**Re: Security Fire Station No. 4 – 7600 Wayfarer Drive (PPR-20-029, CON-22-028)**  
**Engineer's Punch List Response**  
**M.V.E. Project No. 61134**

This letter is the engineer's response to Preliminary Acceptance Punchlist issued for the project on 5/24/2023. Responses, if any, are in bold type.

**C1.3** MVE PROJECT 61134  
 MVE DRAWING GEC-PP

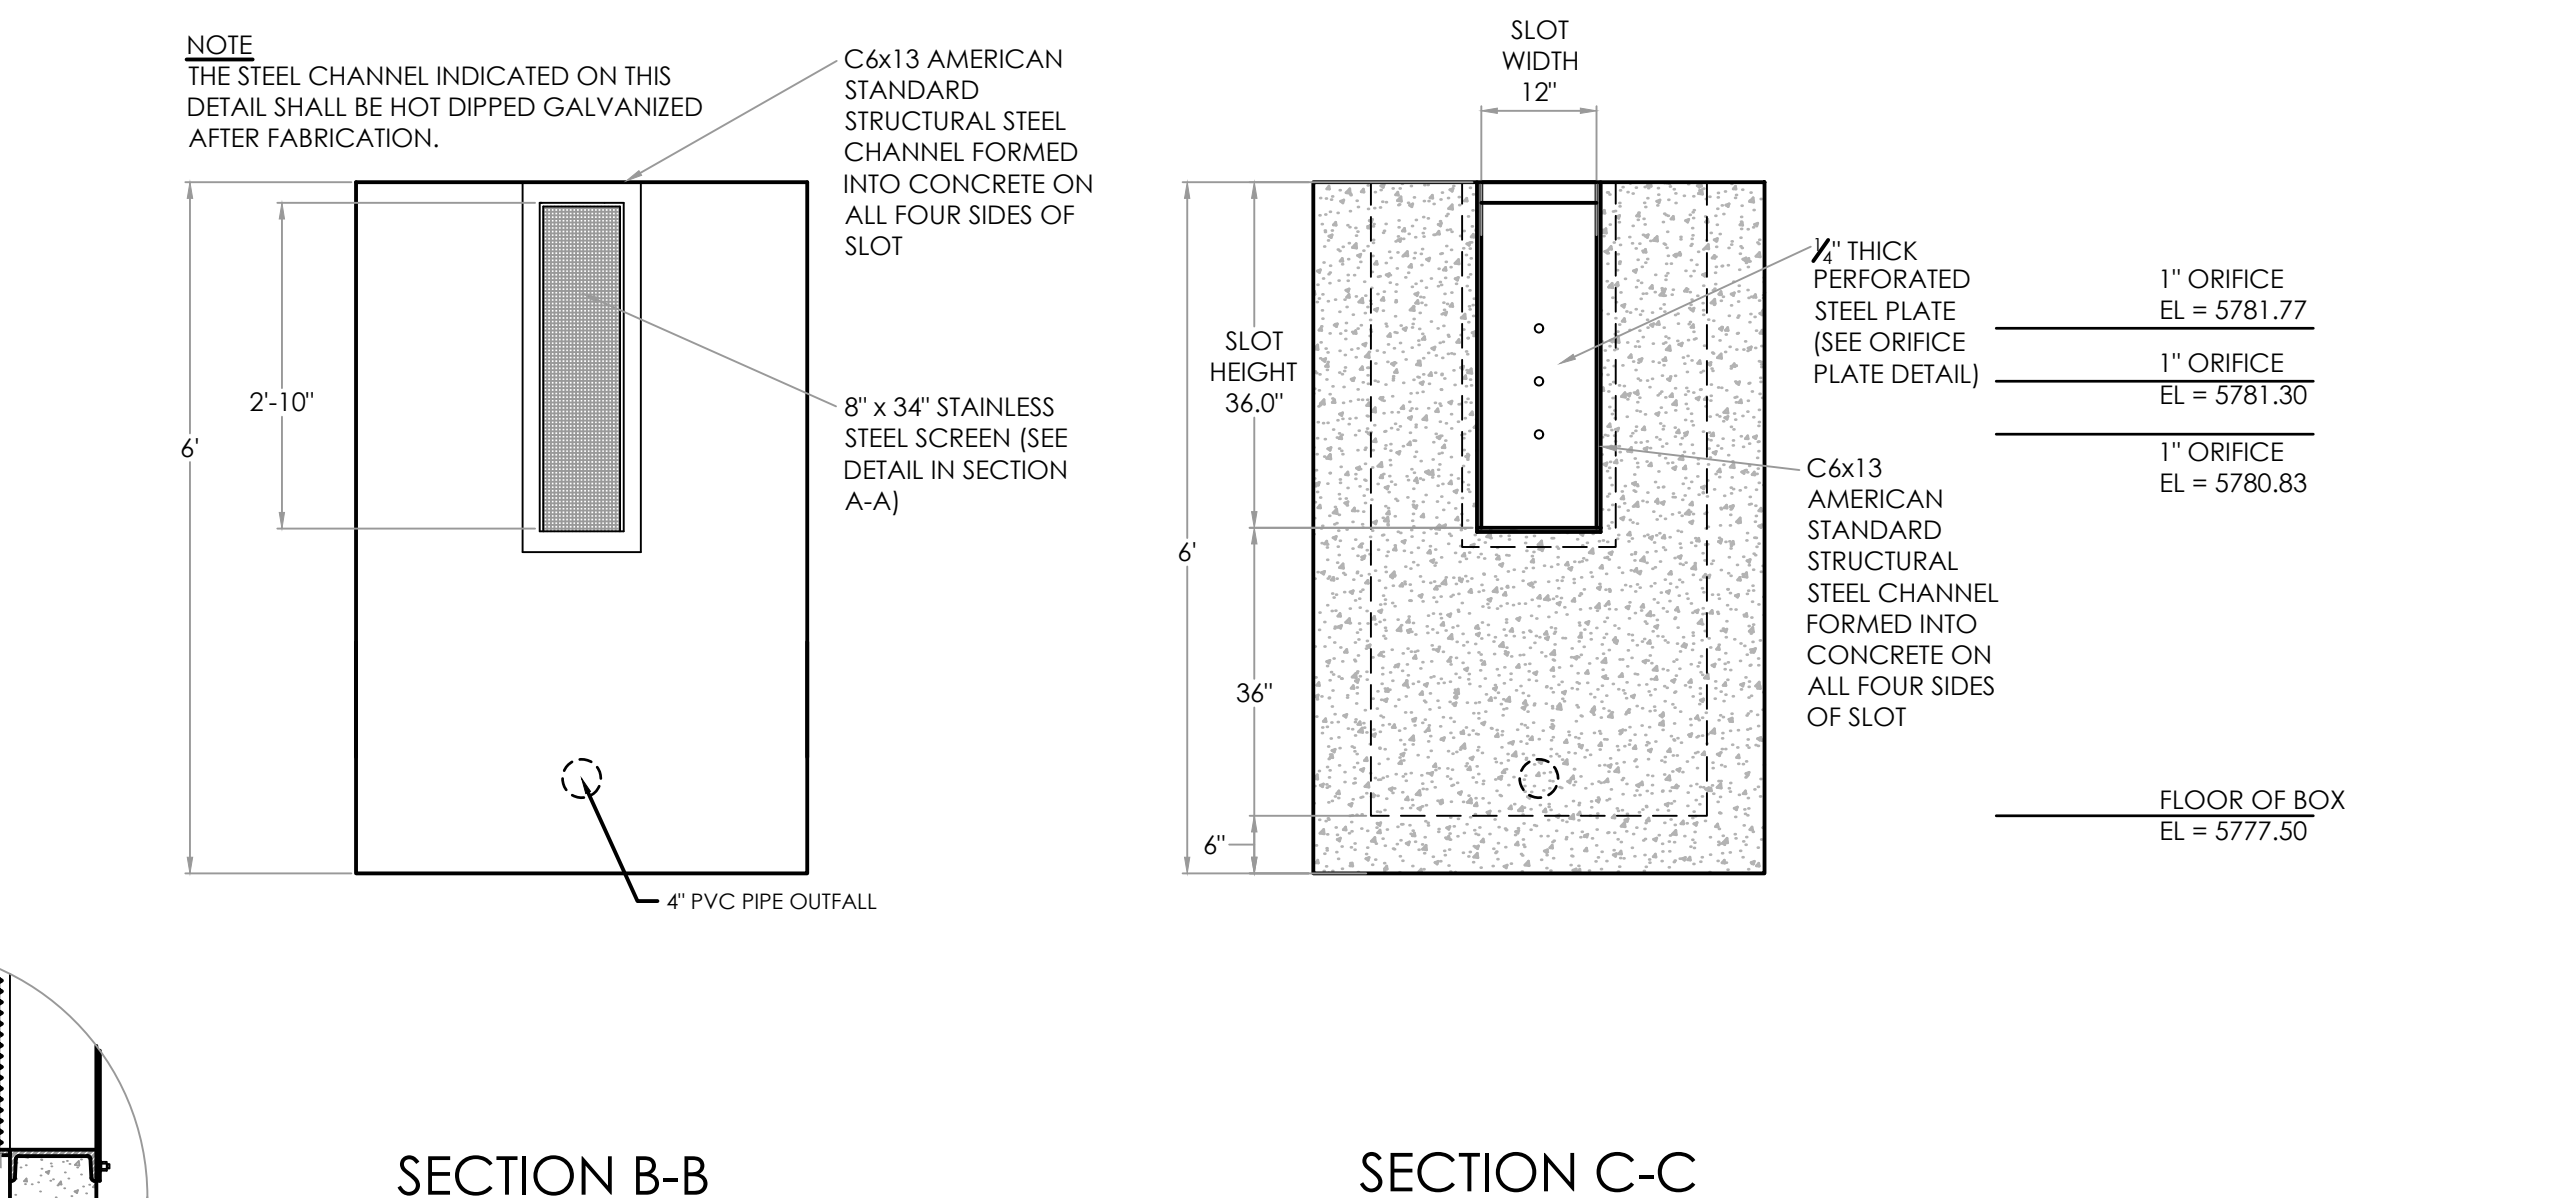
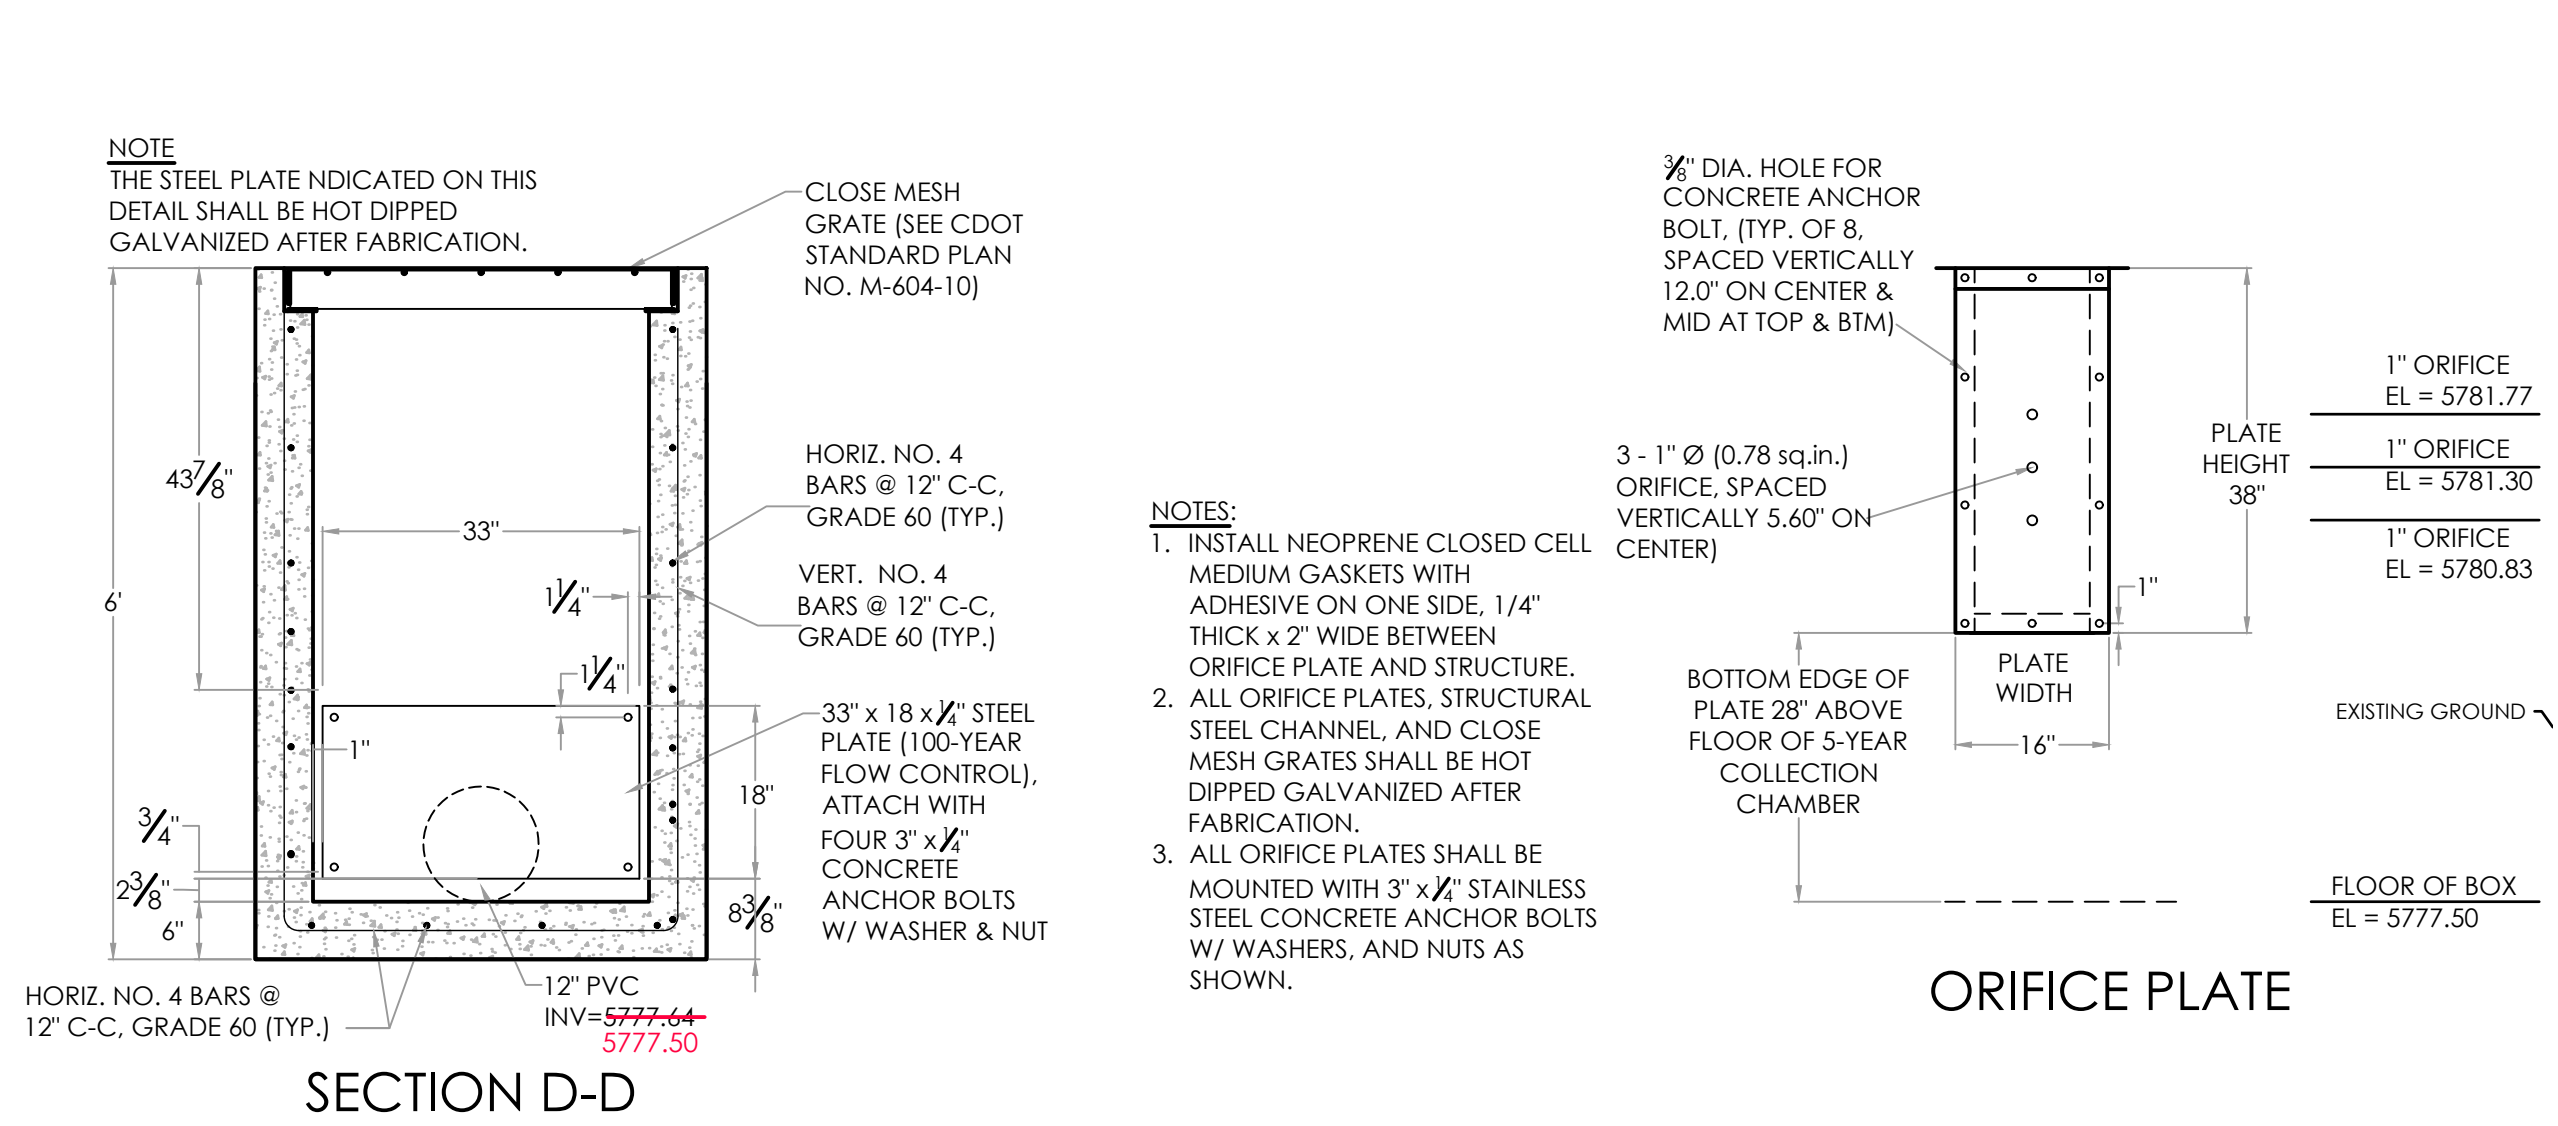
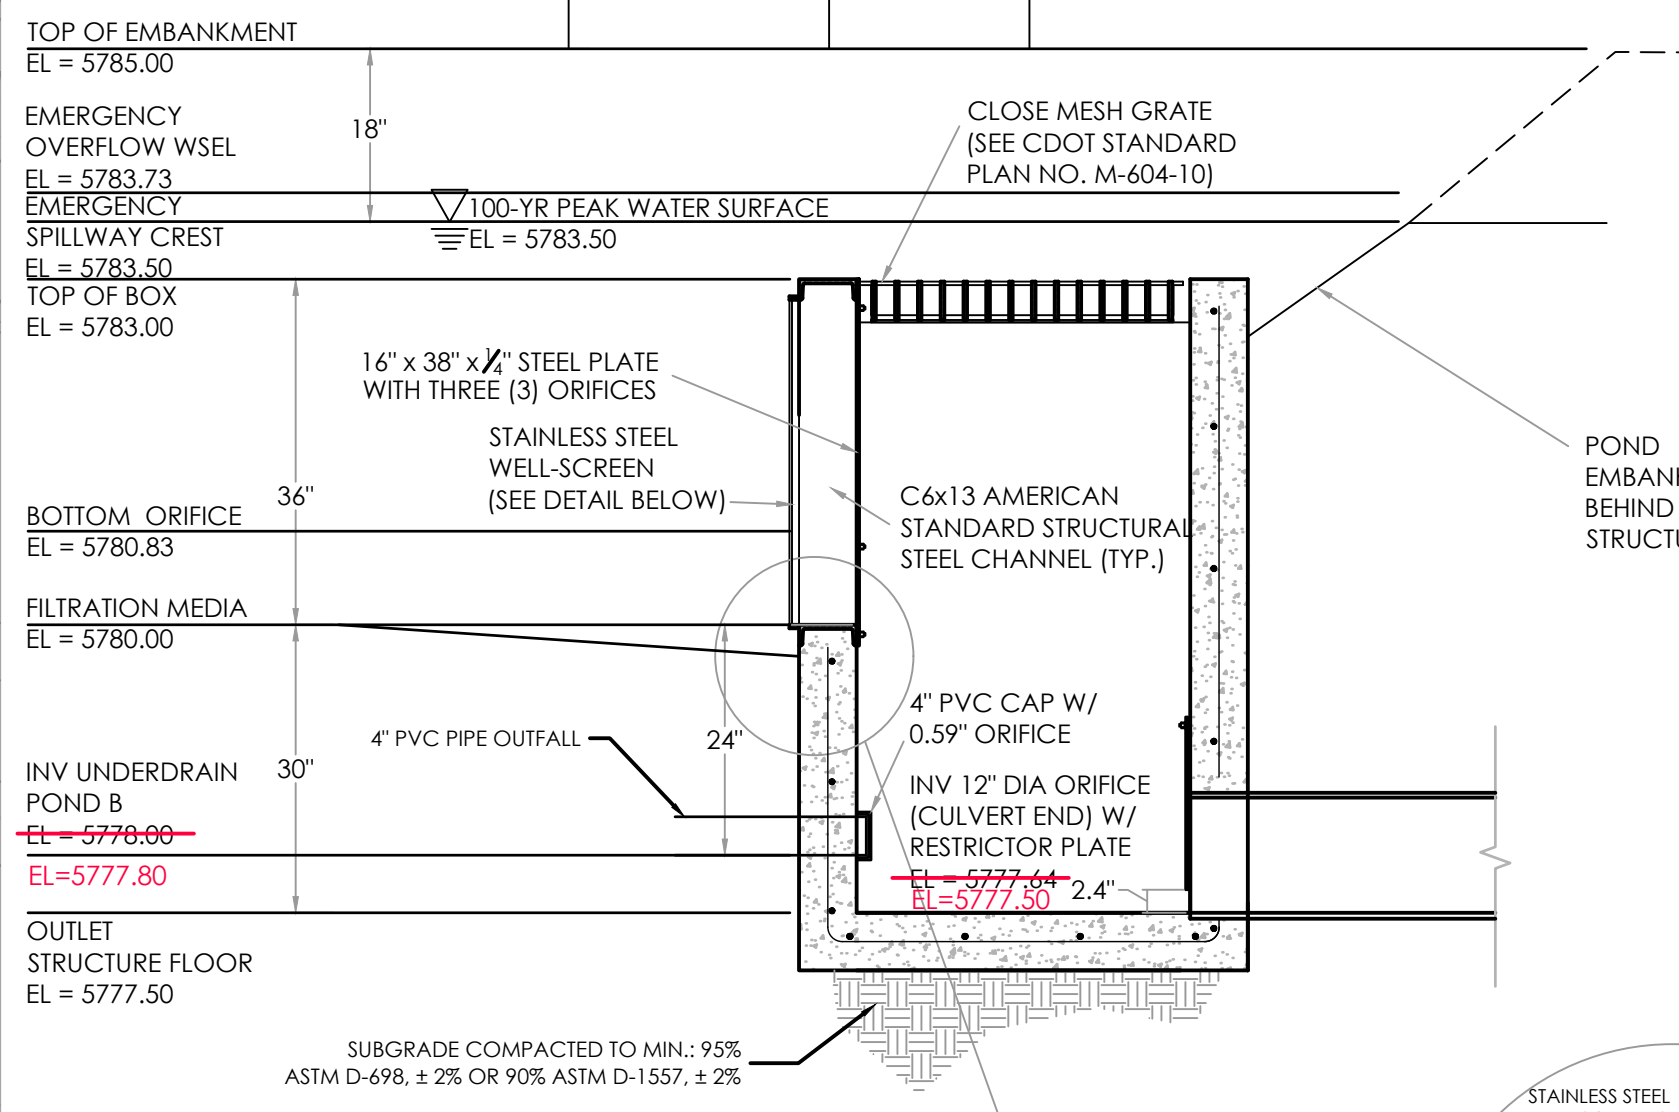
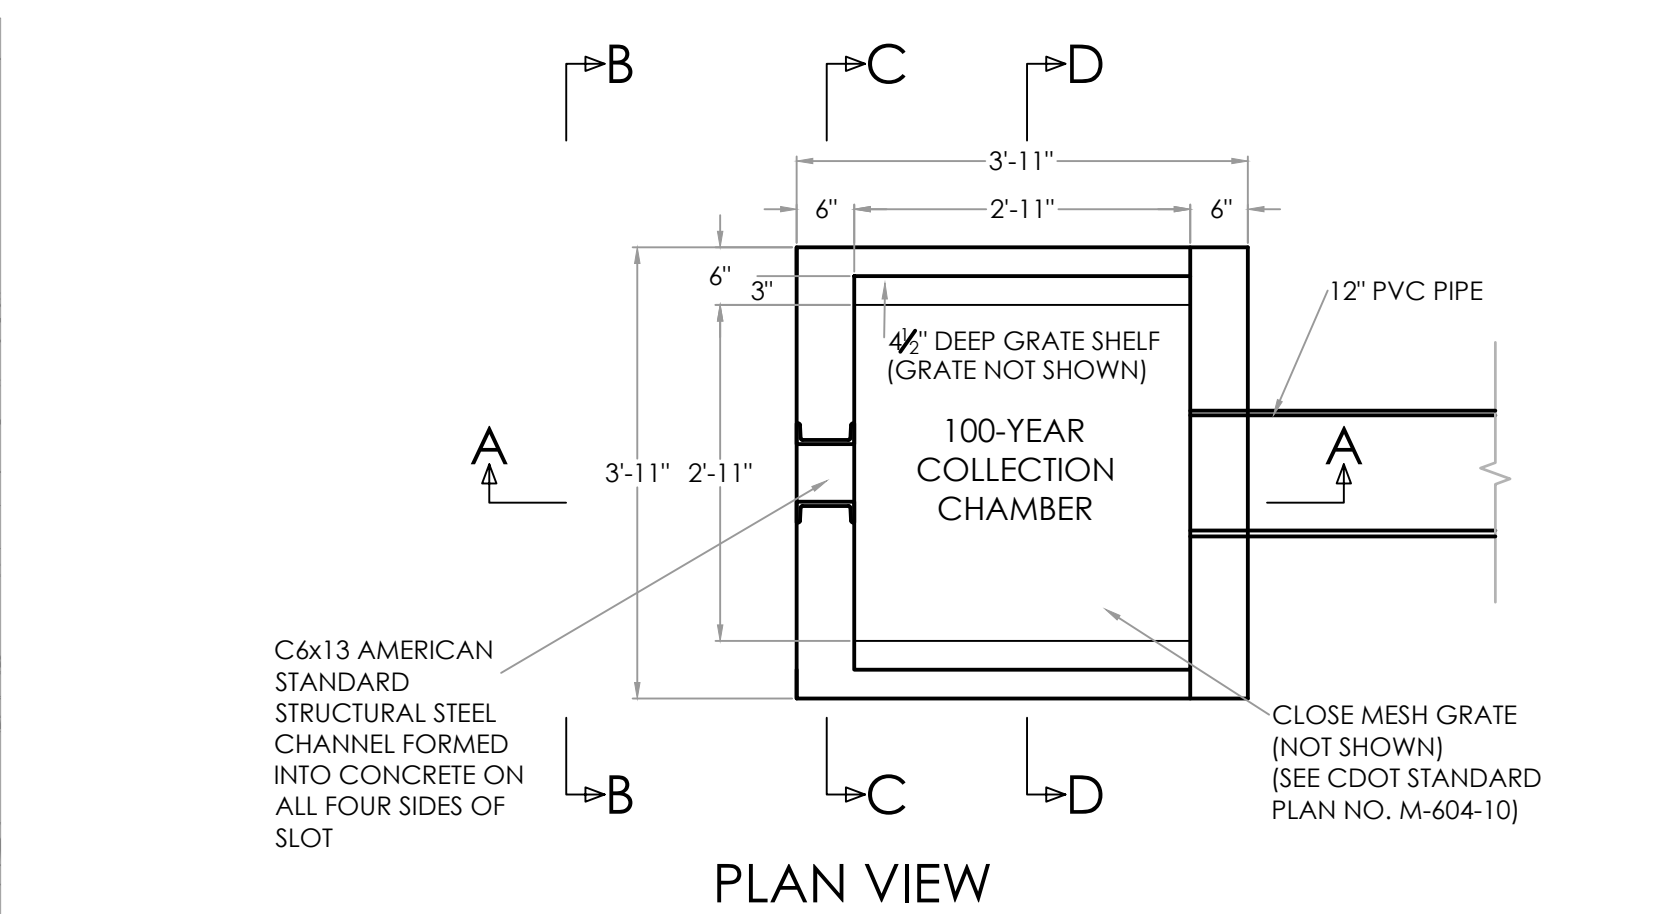
- Undercutting occurring at riprap rundown at southeast corner of pond – **Engineer requested that the voids in rip-rap be filled with 3/4" to 3" rock to protect fine material beneath the larger riprap rock.**
- Area drain at north east corner requires re-grading to promote positive drainage. - **The area drain and grading at the northeast corner of the building are observed to be installed according to the plan functioning as intended with positive drainage to the inlet and away from the building. No changes are necessary.**

- Space between microscreen and orifice plate is not enclosed as shown on plans. This is a maintenance concern. In the field we discussed potentially bolting on a metal plate to cover the gap. Discuss options with project engineer. - **Contractor agreed to install a plate to close off the referenced gap.**

- Section A-A shows the dimension from the invert of the underdrain to the bottom of the orifice plate at 30". However, the field measurement was closer to 34". Make sure that this difference is reflected on the as-built plans and on the updated UD-Detention spreadsheet, because that may have affected the elevation of the orifice holes. - **The invert of the underdrain at the box interface was constructed 0.20' lower than the elevation shown on Section A-A. The elevation of the three orifice holes in the orifice plate are within survey tolerance of the design elevations shown on the plan. The as-built drawing indicates the as-built elevations. Top of box elevation, and spillway crest elevation is also located within survey tolerance of**

• Similar comment for the invert of the outlet pipe: Section A-A shows the invert of the outlet pipe to be elevated 1-5/8" above the bottom of the outlet structure. But it was instead installed flush with the bottom. Reflect on as-built drawings and calcs. - **The elimination of the 1 5/8" gap for the outlet pipe is shown on the As-Built and included on the updated UD-Detention Worksheet. No significant changes to the pond operation result.**

**the design elevations. The UD-Detention Worksheet has been updated to reflect the revised underdrain outlet elevation which slightly decreases drain times of the EURV and 2-yr storm by one hour, but remains within state requirements for drain times. There is no need to update the SDI for this pond.**
